## Application for a Non-Material Amendment Following a Grant of Planning Permission

Single storey side and rear extension following removal of existing carport and detached garage.

23/02217/FUL

Circular window to front elevation replaced by rectangular window to match existing.

FRONT ELEVATION

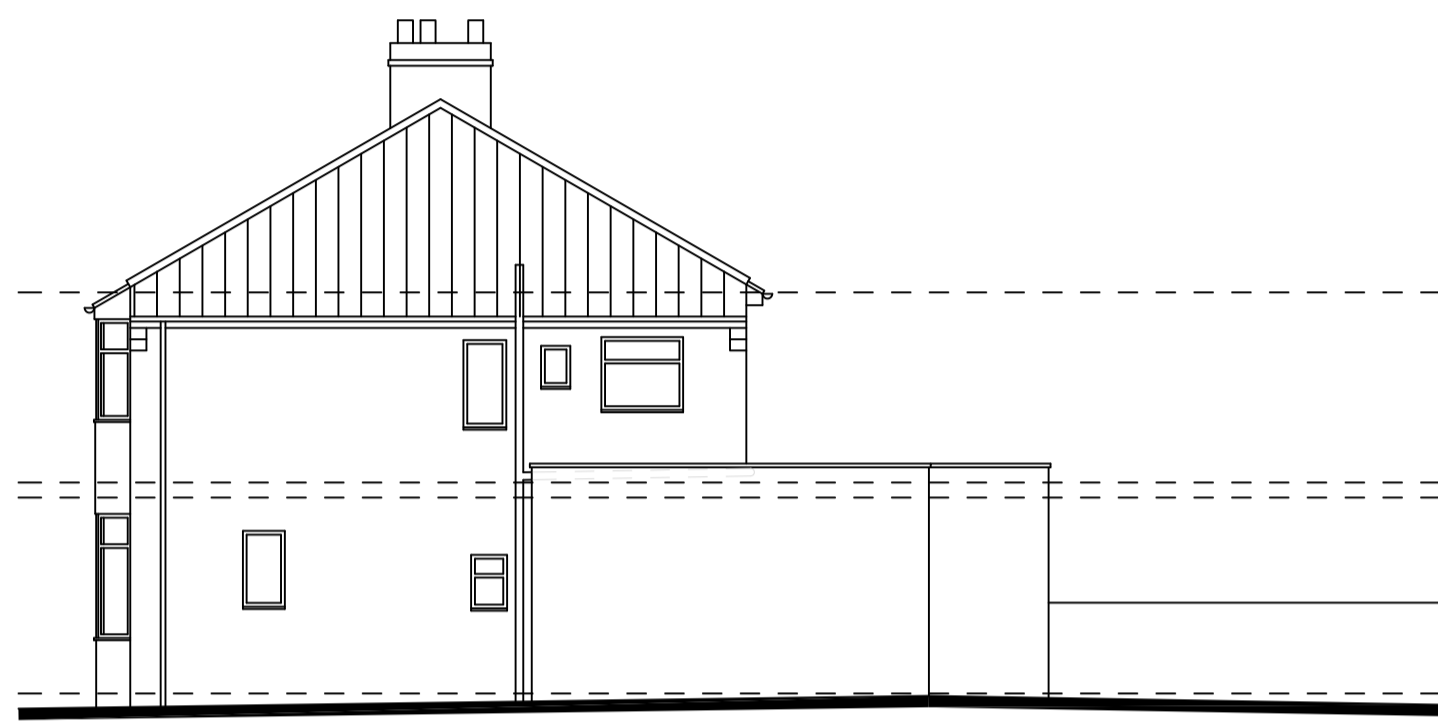
To be more functional and more in keeping with aesthetics of the existing dwelling.
